## MEMORANDUM

SUBJECT: SF-21-010 – The Hills at Lorson Ranch Filing No. 1  
First Submittal Response to Comments

Exhibit A: LANDSCAPE IN ROW AREAS AND MAILBOX KIOSKS

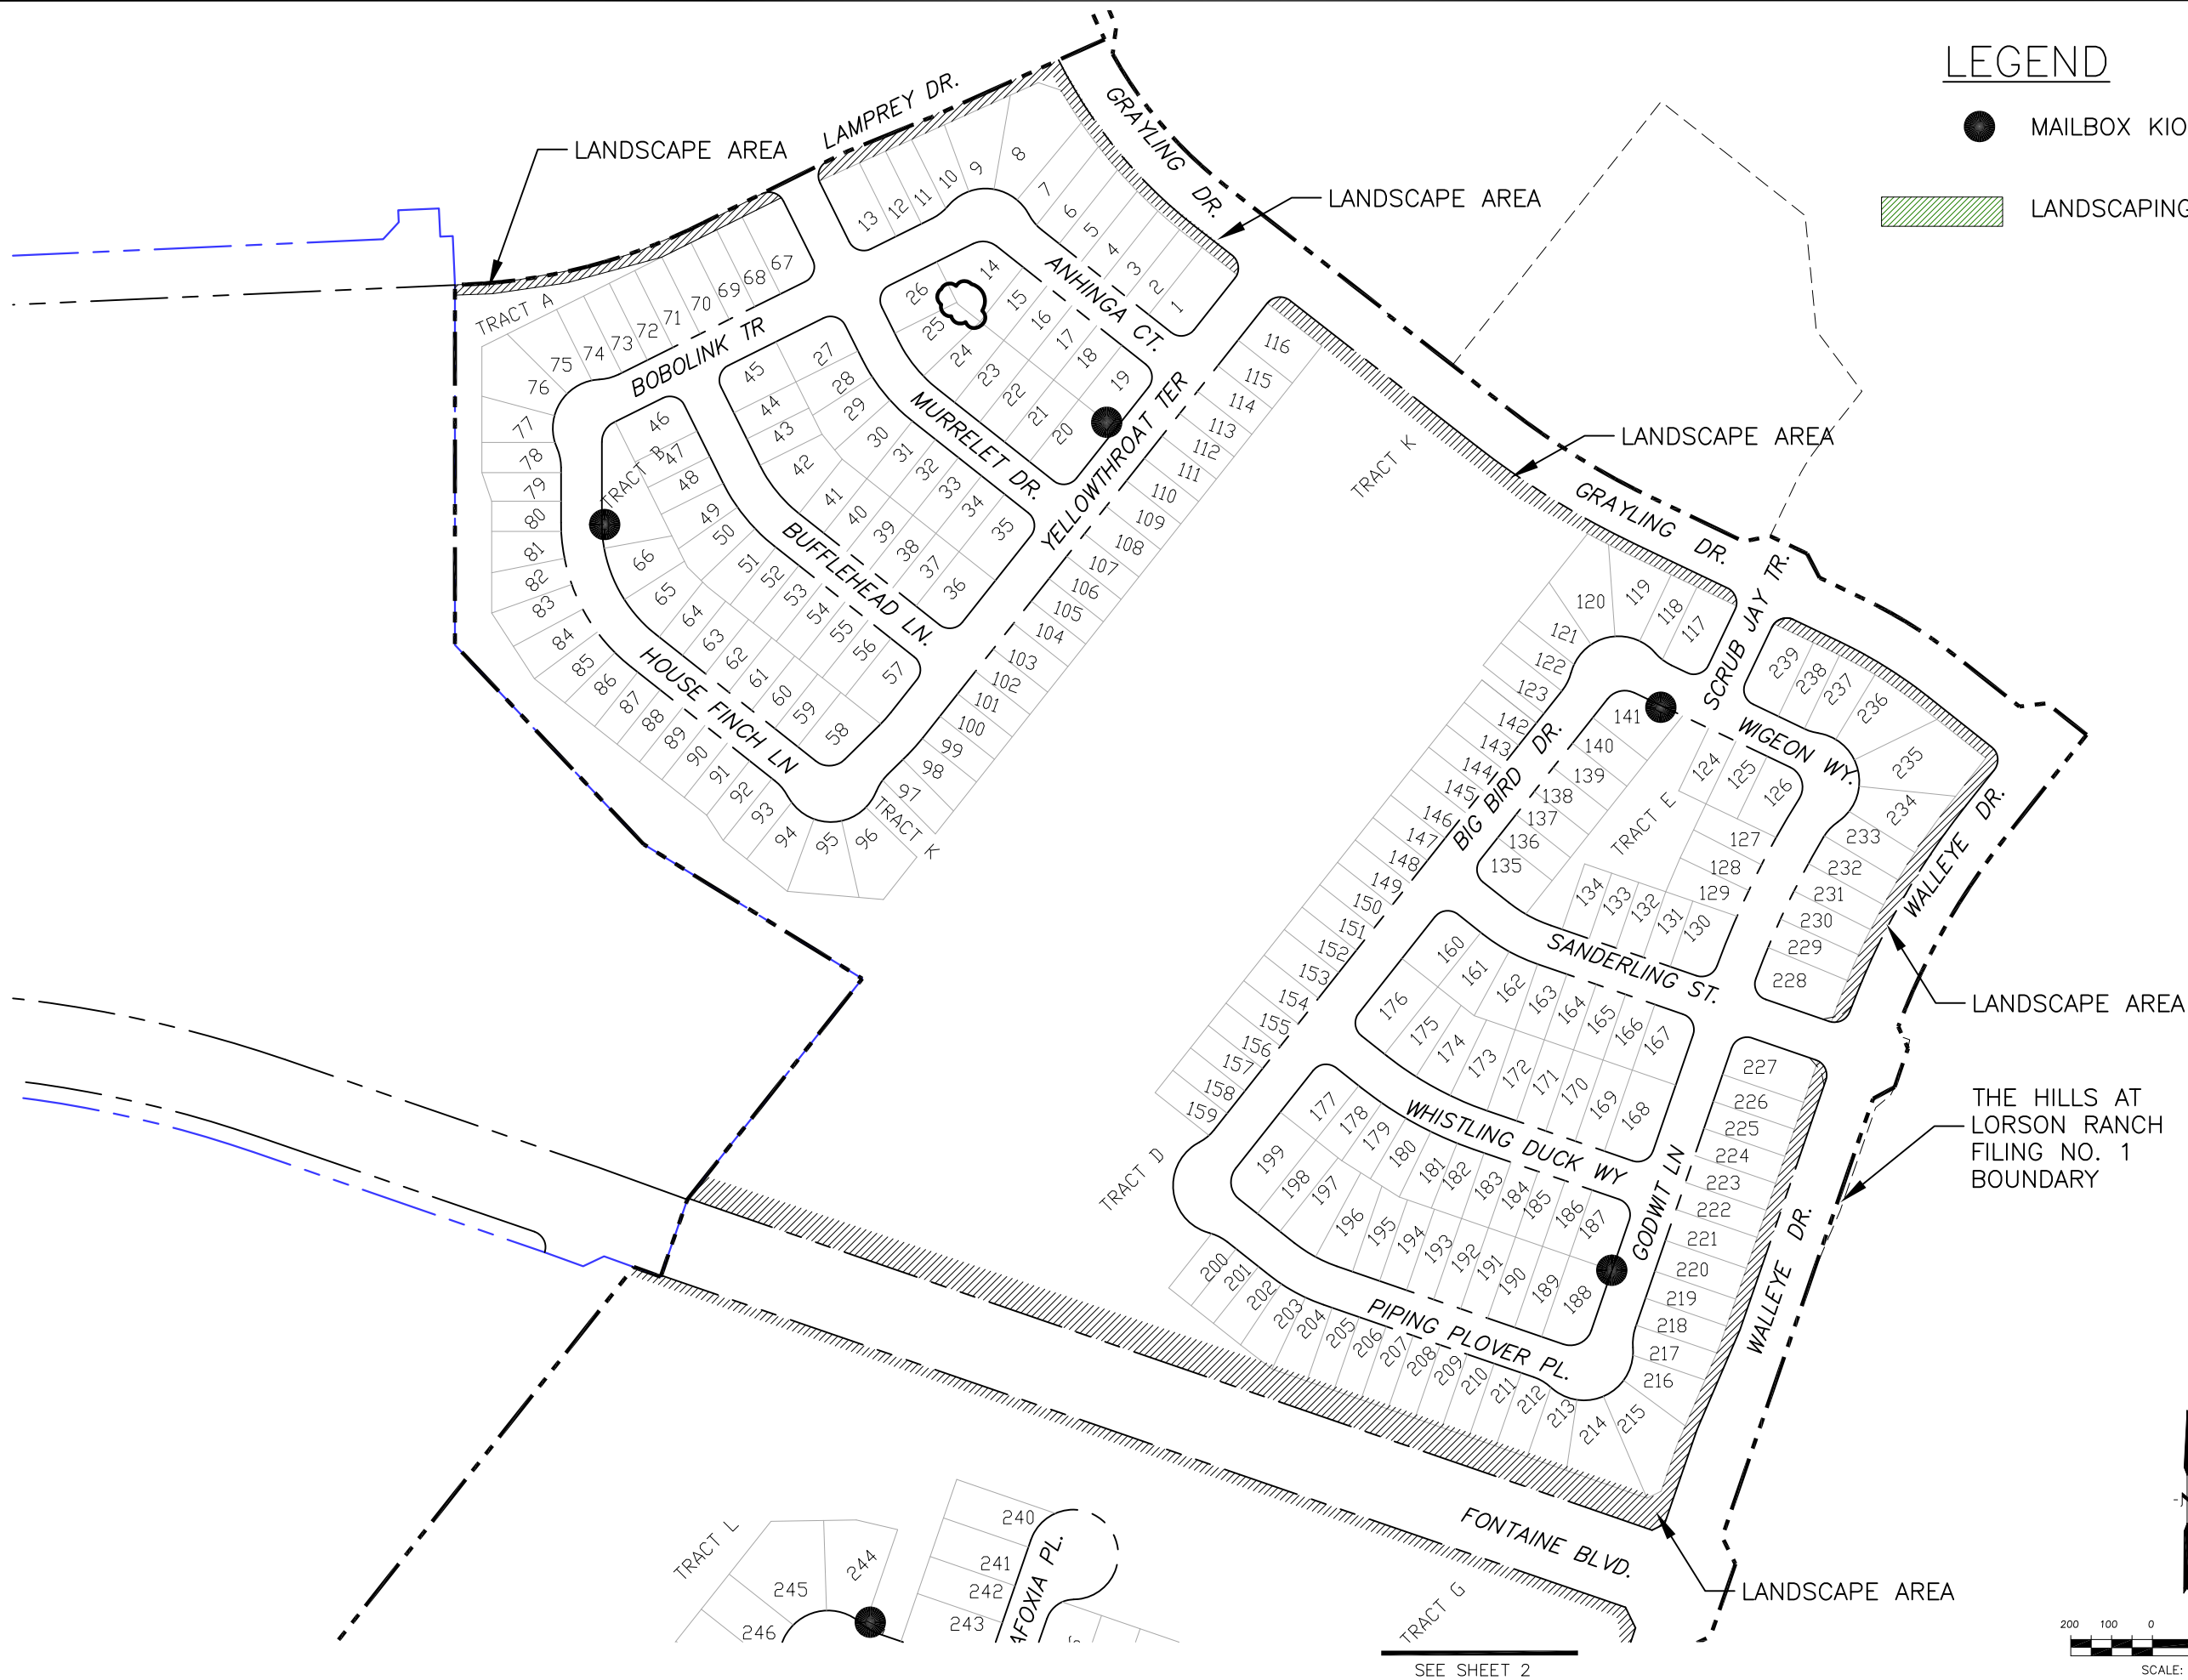
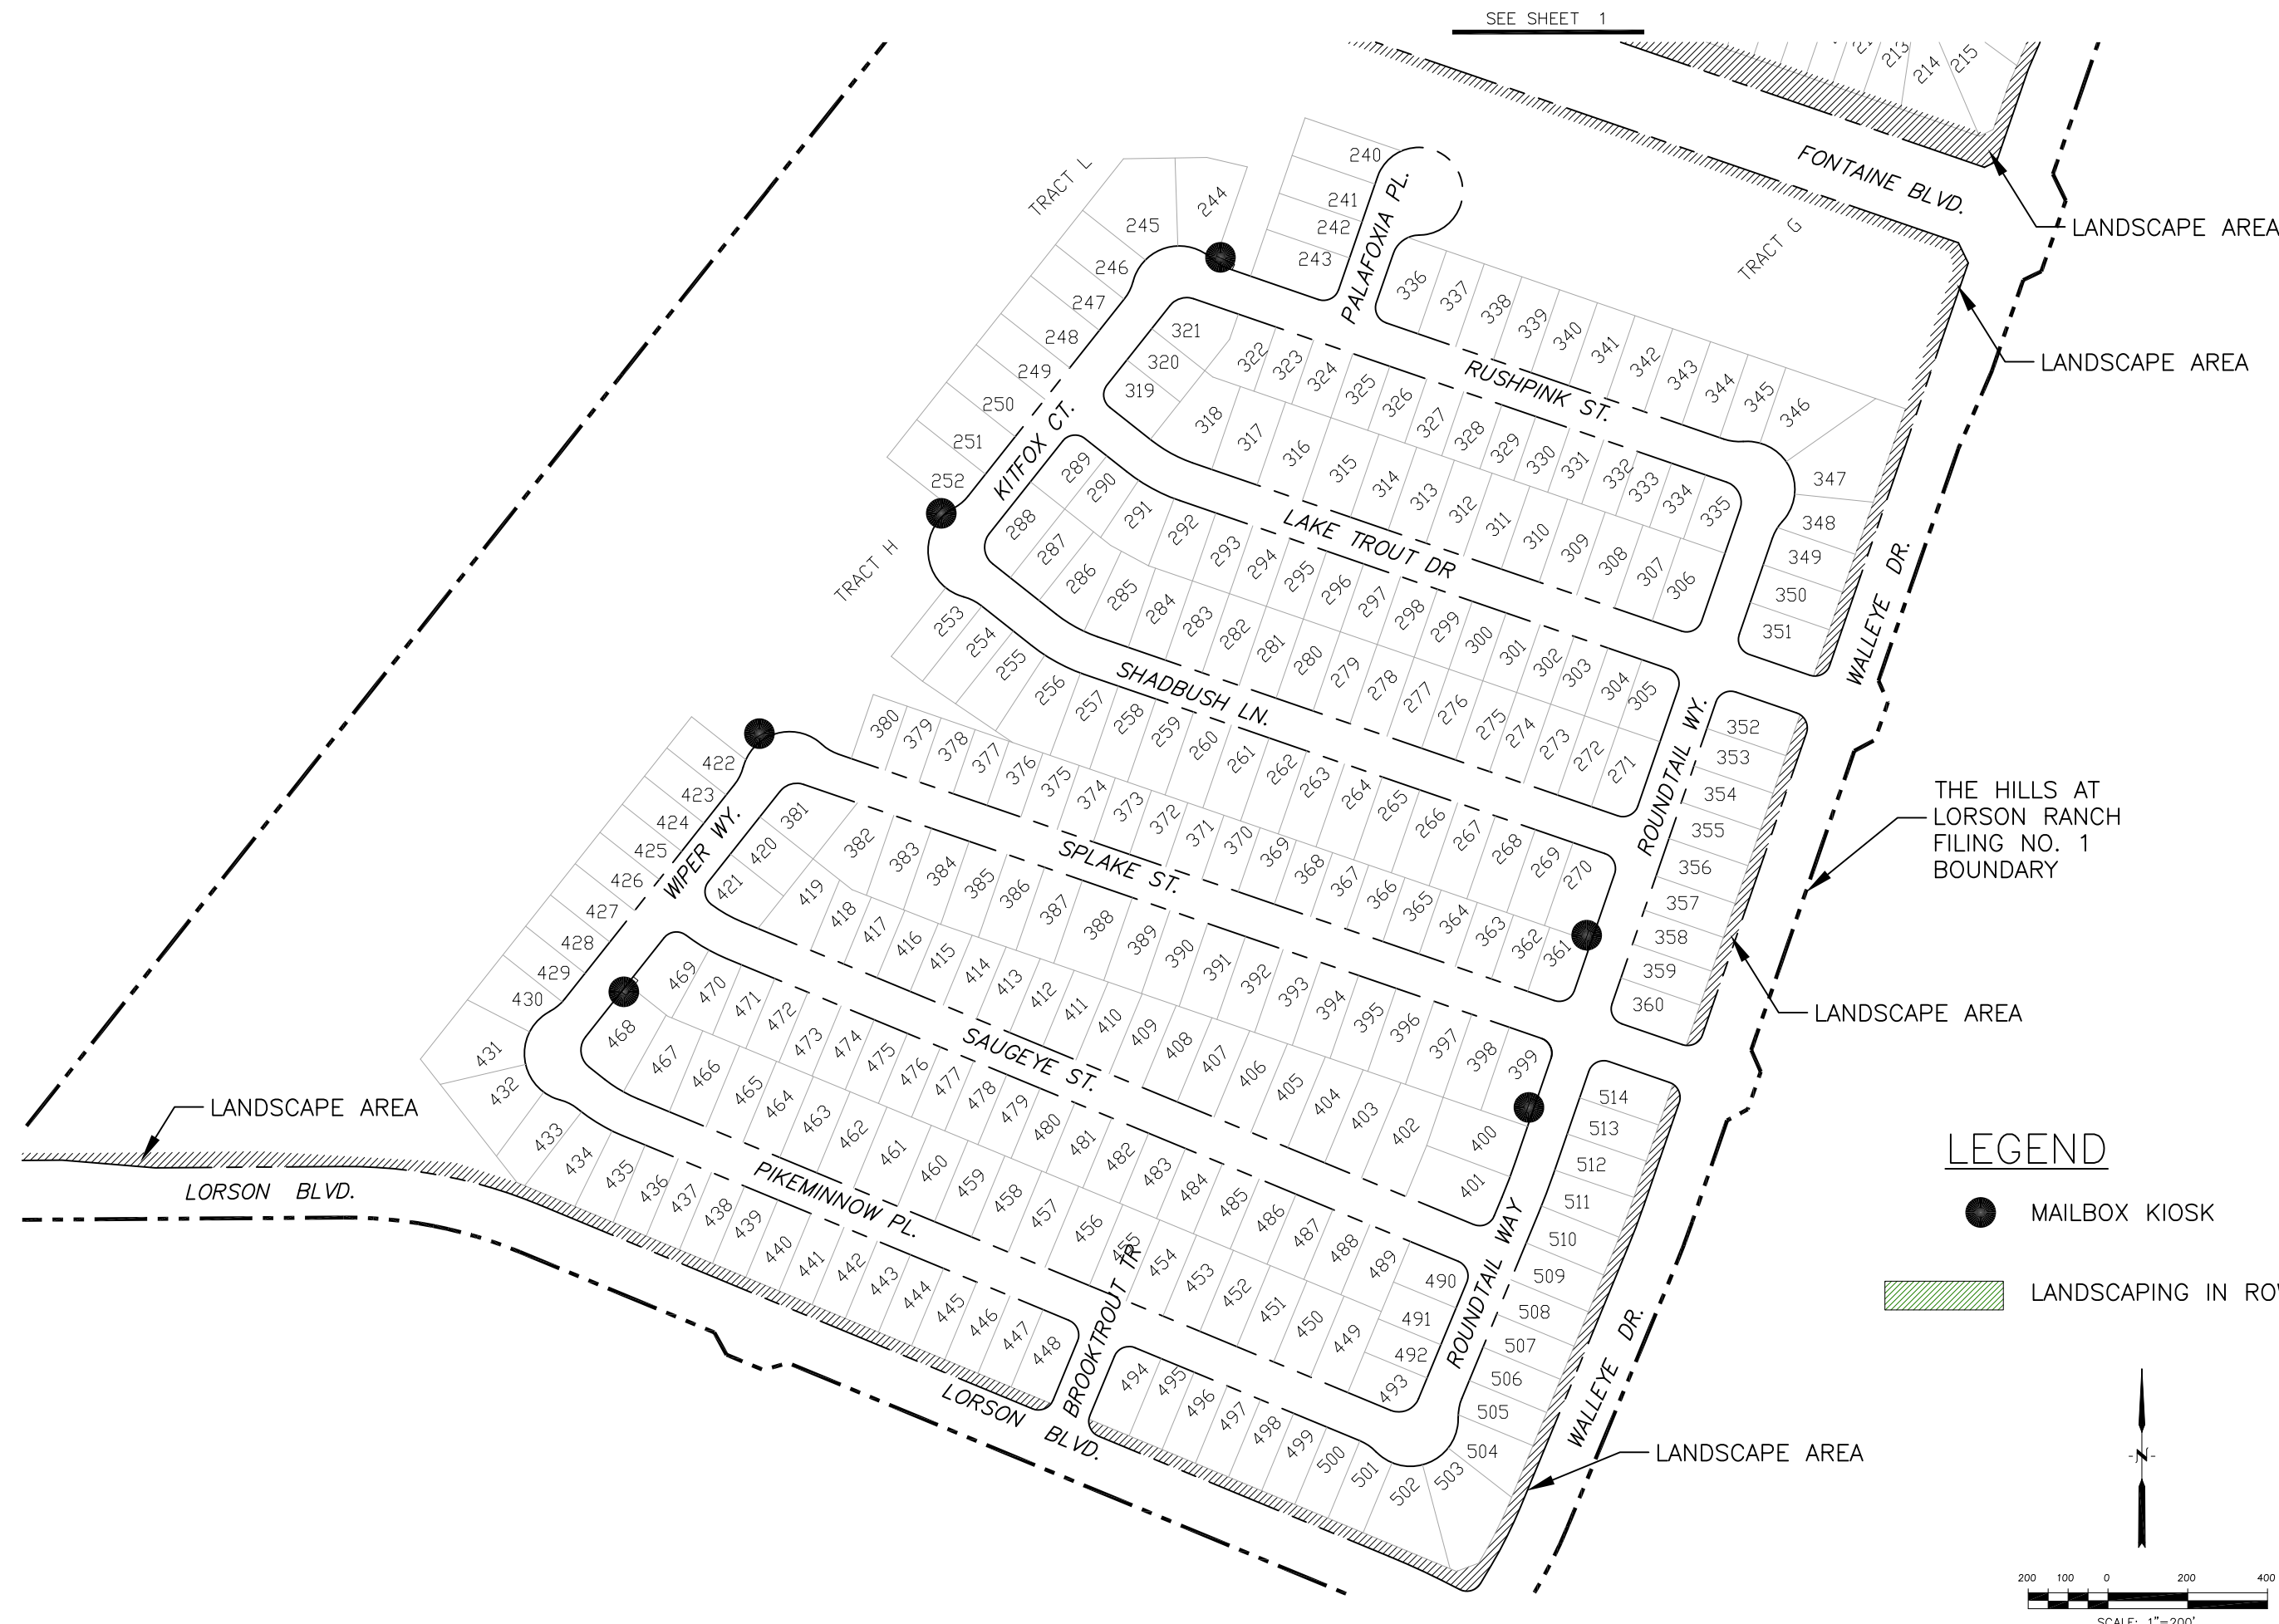
1. Provide USPS mail kiosk/cluster details. A license agreement is required. *RE: We have requested the details from USPS and will provide once received. The ROW agreement has been submitted and will be updated for kiosk locations.*

3. Note: County acceptance of the roads after completion will require vacation or subordination of utility easements coincident with the ROW, such as easement 218025811 overlapping Grayling Drive. *RE: water/sewer easements will be vacated.*
4. Note: The MS4 Post-Construction Documentation Form and SDI worksheets were reviewed with PUDSP-20-003.
5. The license agreement exhibit needs to show any mail kiosks in/using the right-of-way. *RE: we will show them.*
